DRB CASE ACTION LOG (SITE PLAN B.P.)

DRB Application No.: <u>07DRB-00083 (SBP)</u>	Project # <u>1005310</u>
Project Name : <u>RENAISSANCE CENTER</u>	
Agent: <u>Gregory T Hicks & Associates</u>	Phone No.: <u>243-7492</u>

1. Project # 1005310
07DRB-00083 Major-SiteDev Plan BldPermit

GREGORY T HICKS & ASSOCIATES agent(s) for STEVE GRIEGO request(s) the above action(s) for all or a portion of Tract(s) 9-C, **RENAISSANCE CENTER**, zoned SU-1 FOR IP, located on CHAPPELL DR NE, between MISSION DR NE and RENAISSANCE BLVD NE containing approximately 1 acre(s). [REF: 06AA01769, DRB-96-495, V-96-110] (F-16)

LANDSCAPING PLAN

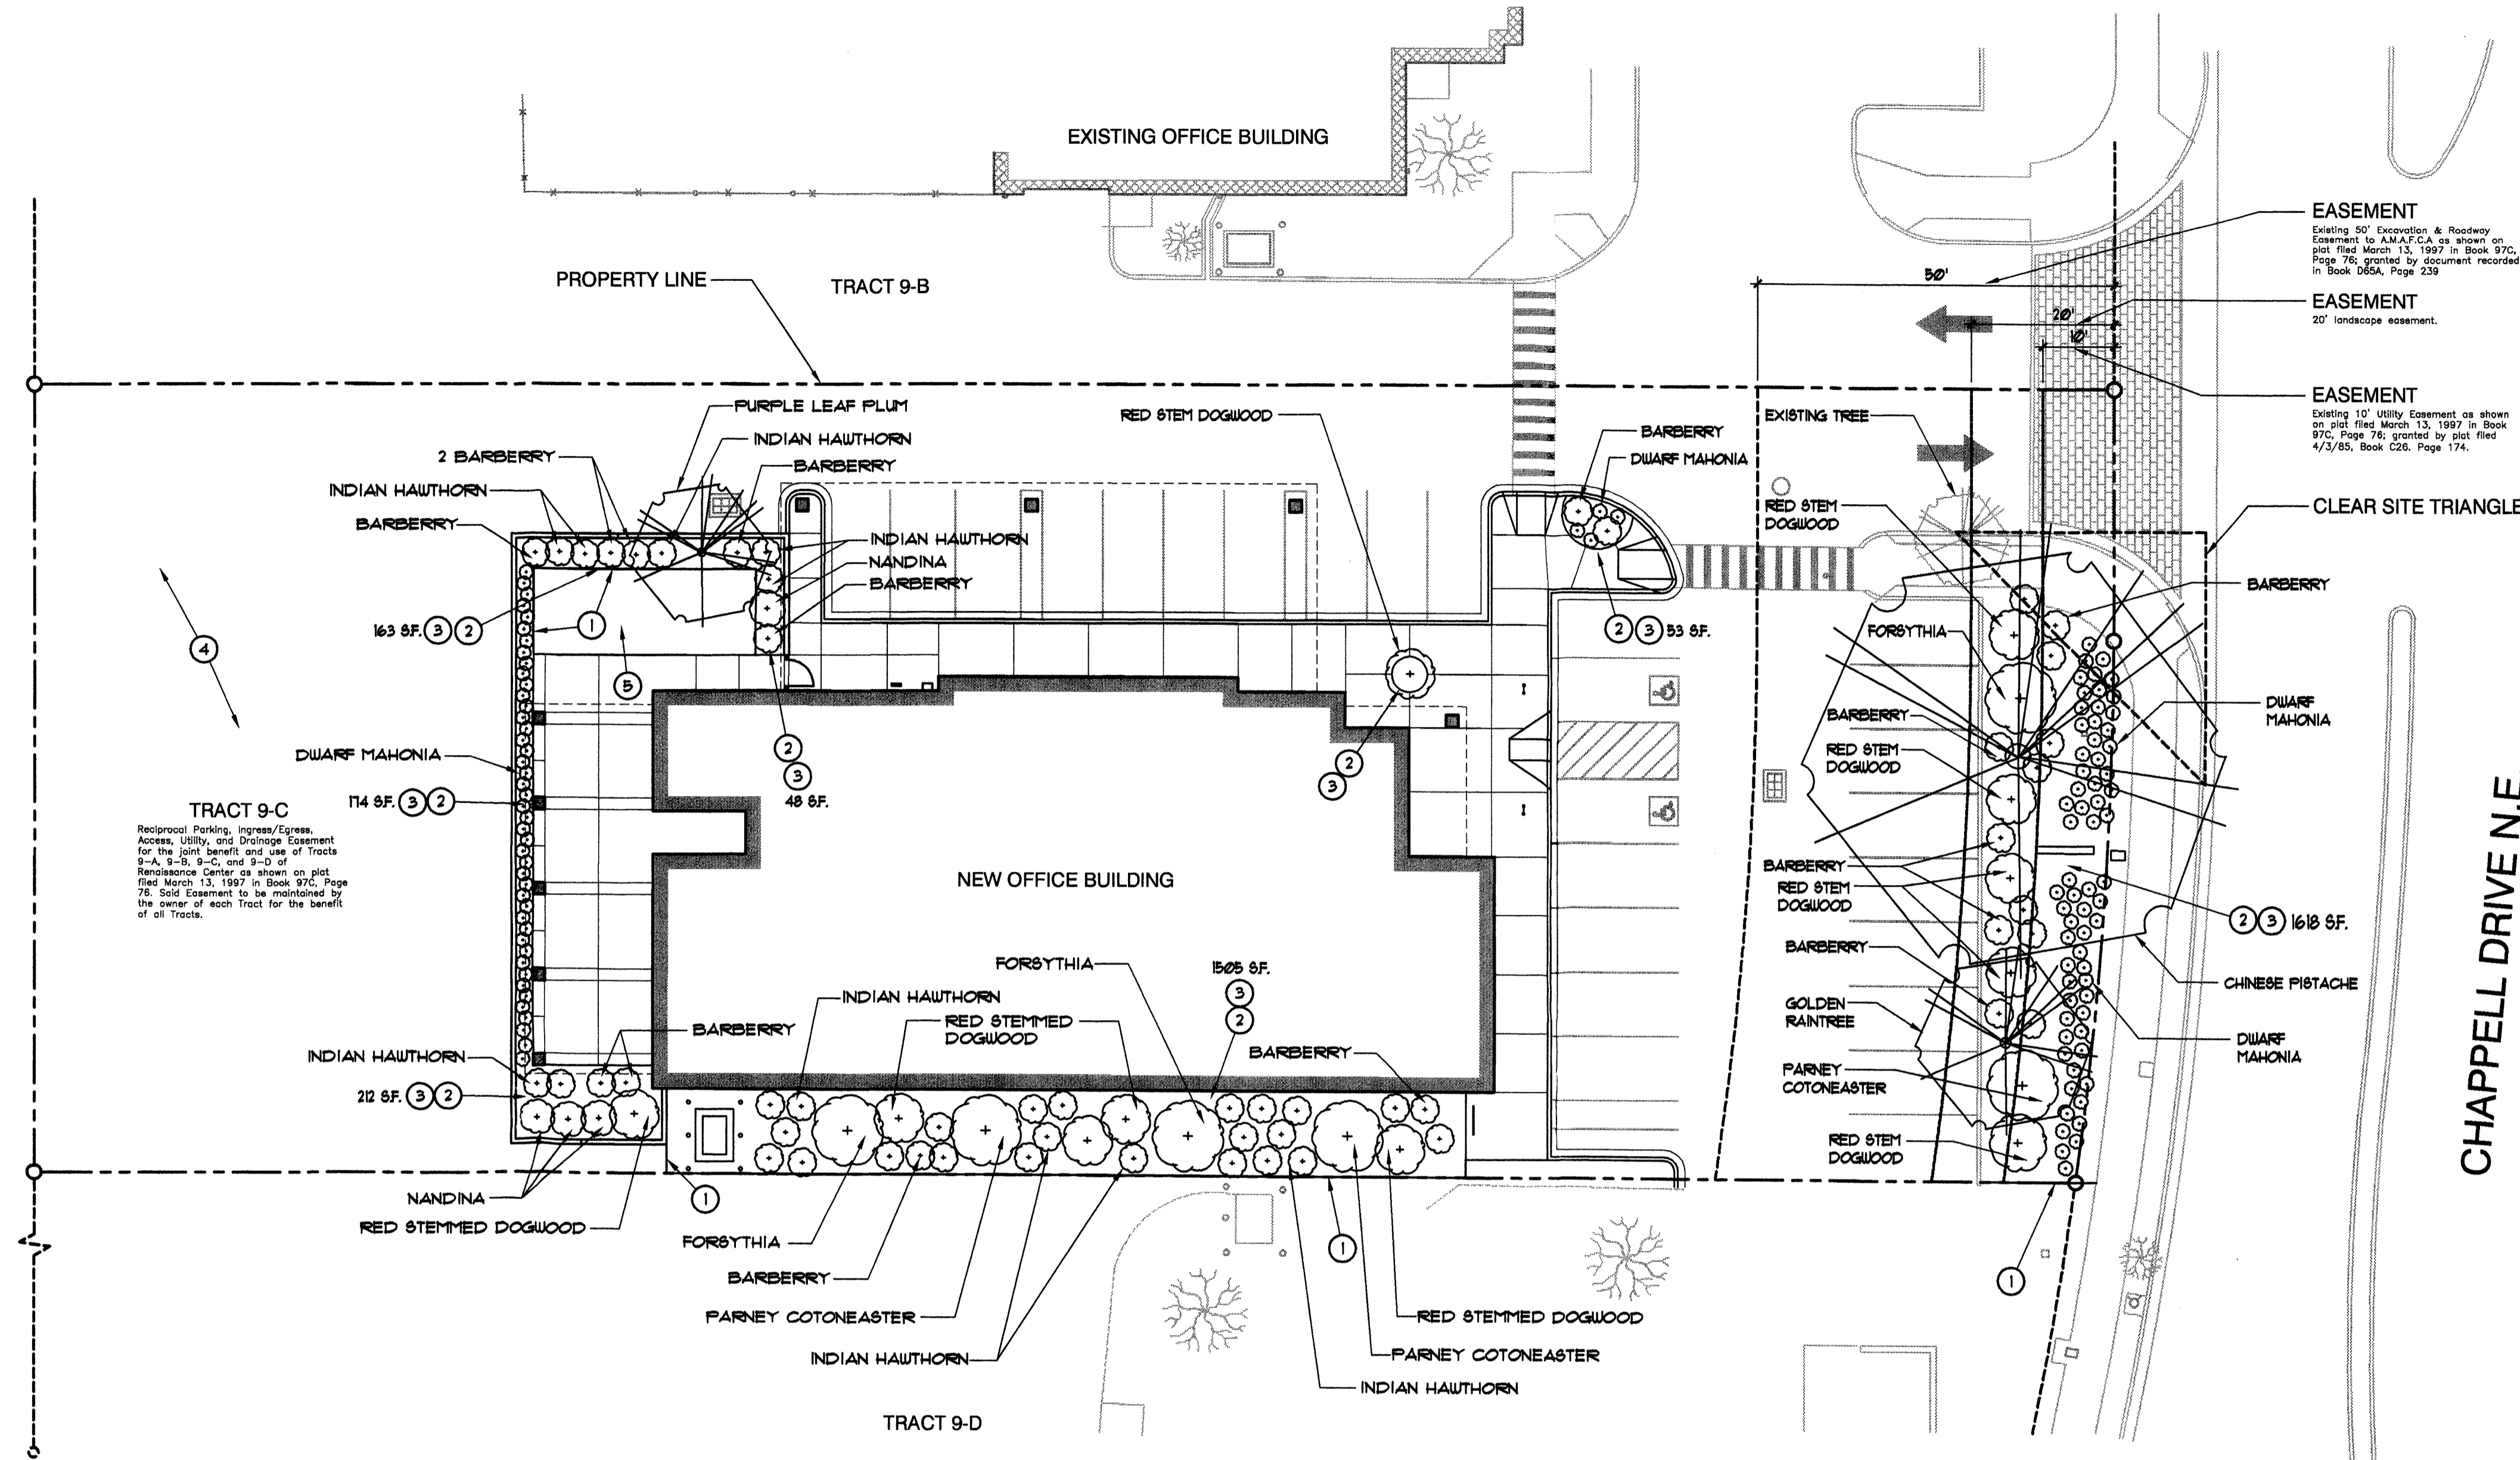
There are some required Landscape Notes missing from the Landscape Plan. Agent was faxed a copy.

A statement requiring a minimum of 3" depth of gravel or crusher fine is also needed on the Landscape Plan.

Page 39 of the Renaissance Center Master Plan requires 4" caliper trees. Only one listed tree, the Golden Raintree is listed in the Master Plan as permissible. The other 3 are not listed. Is there a reason why the developer did not follow the approved list?

**CONCEPTUAL UTILITY PLAN**

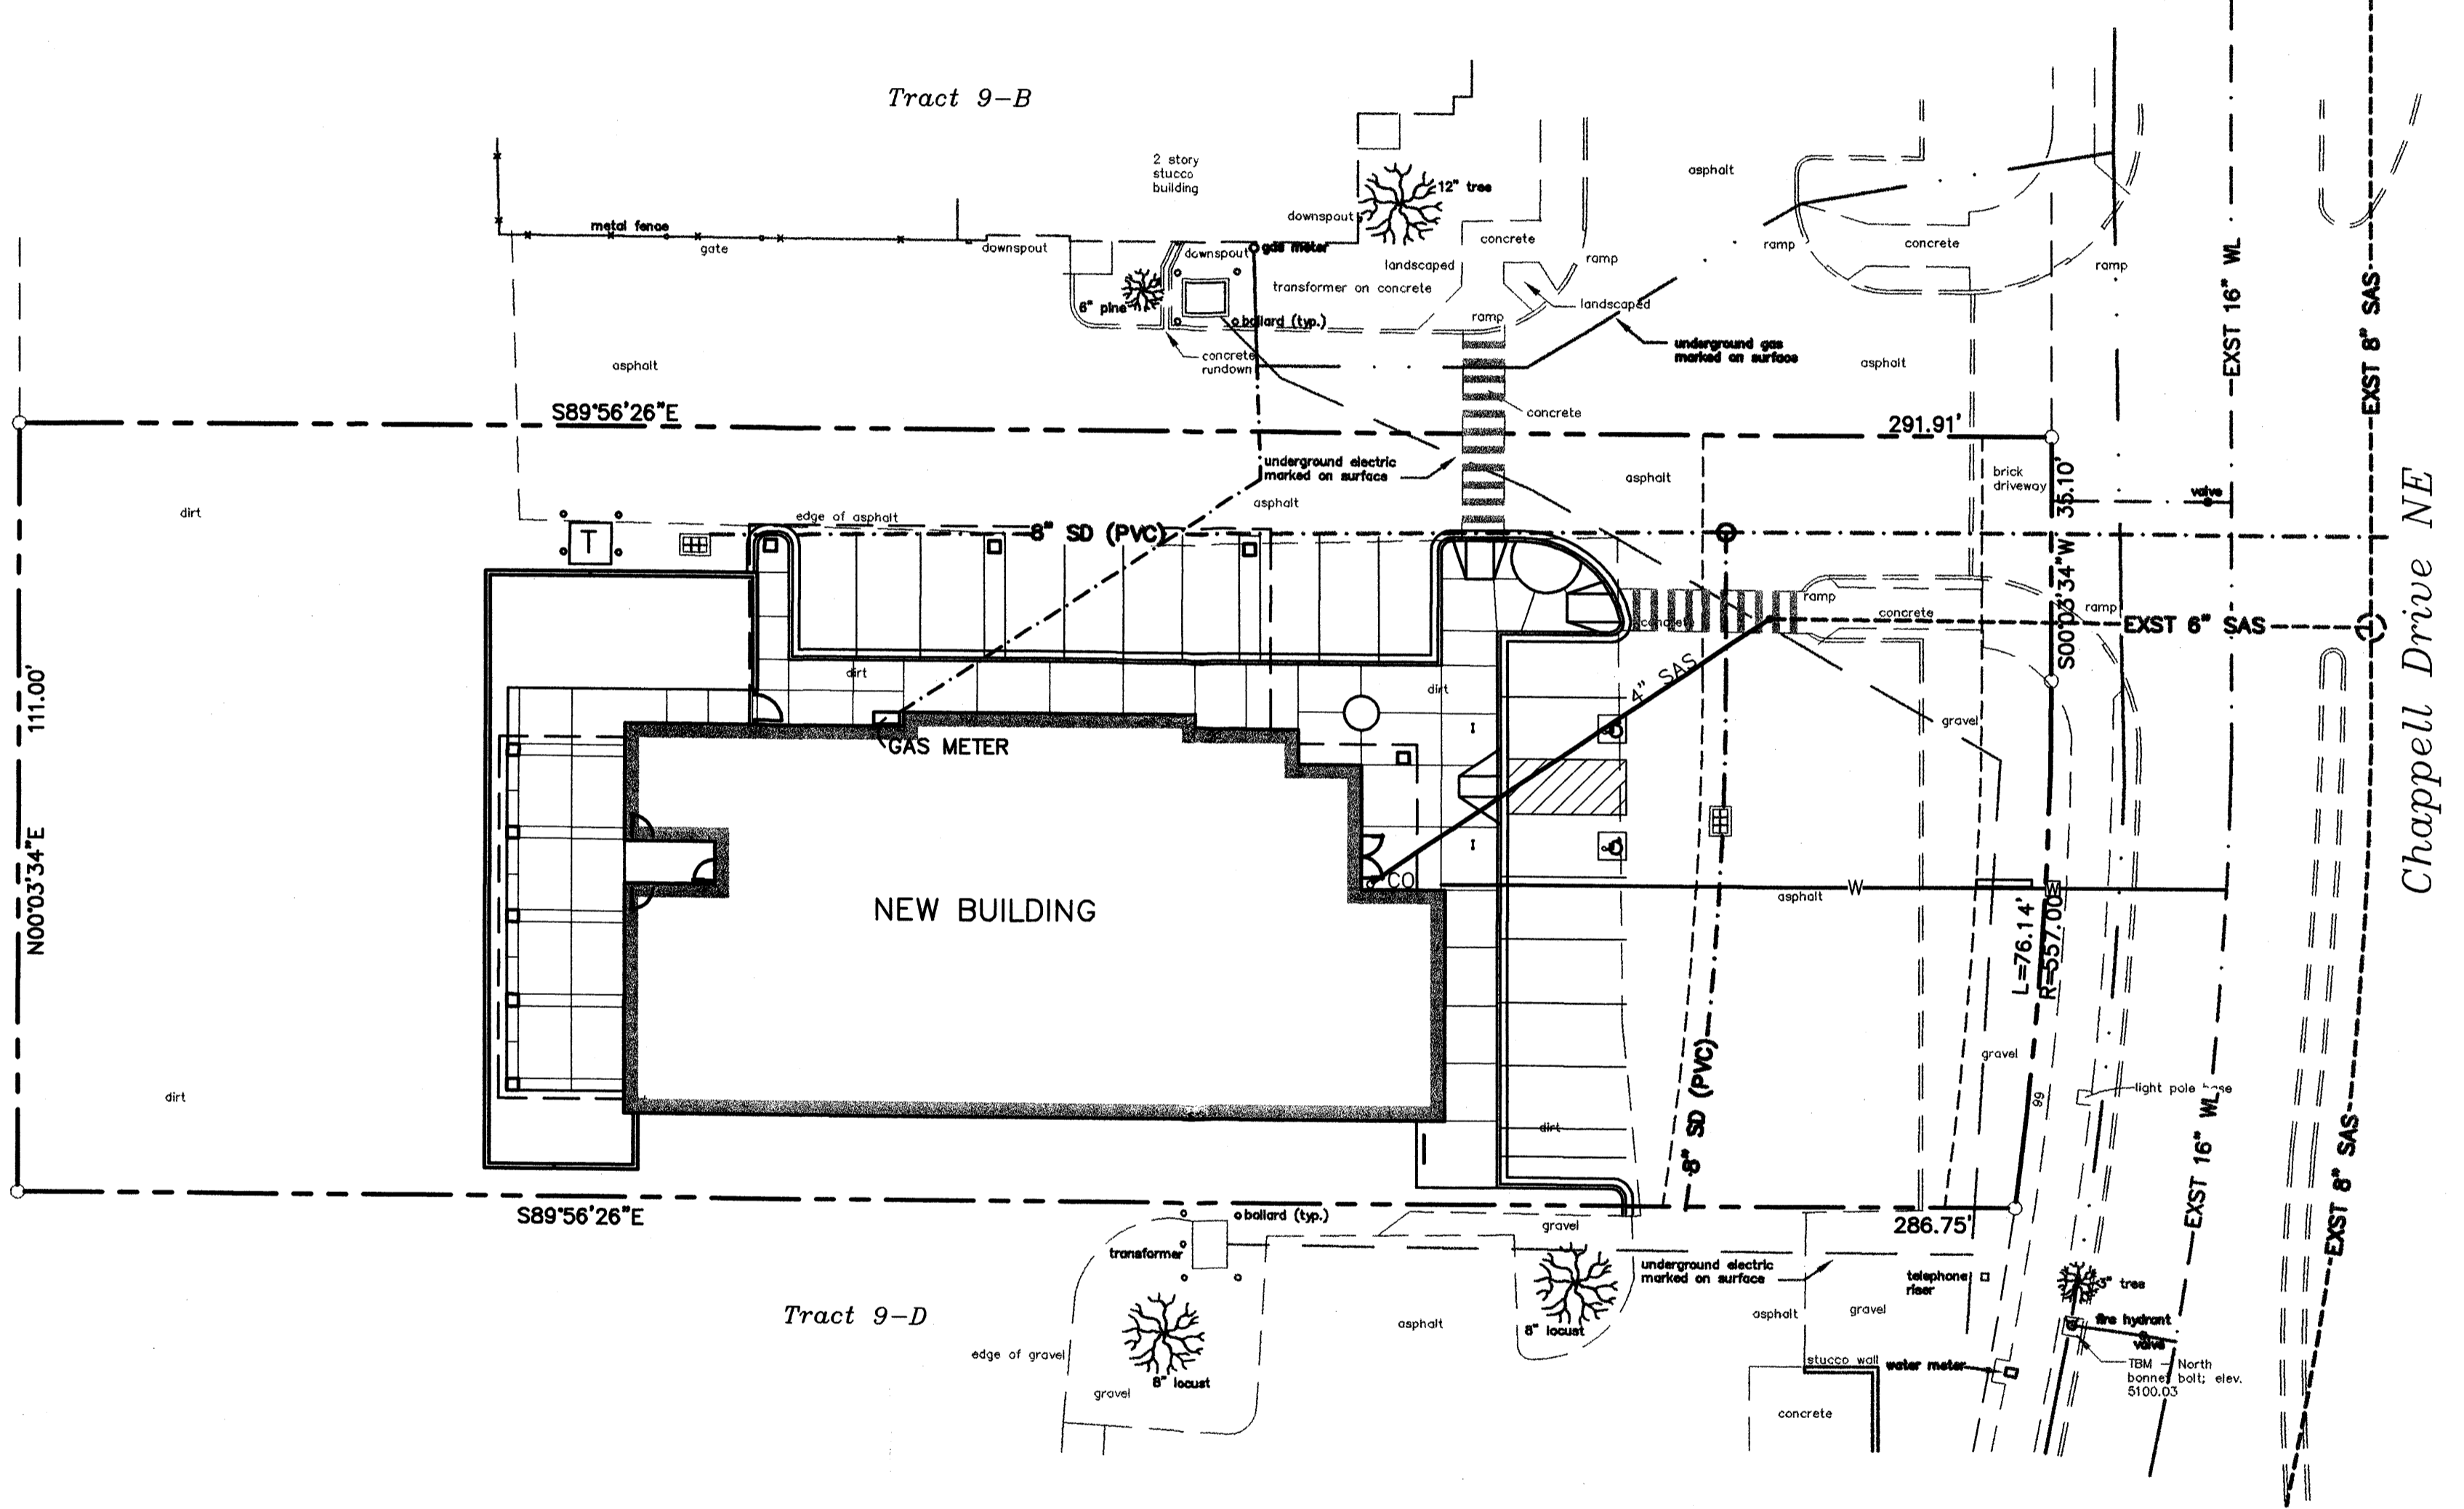
Fire Department This project requires **two (2) fire hydrants**. Utility site plan shows only one (1) fire hydrant. All required fire hydrants shall be installed and made serviceable prior to and during construction of subdivision.
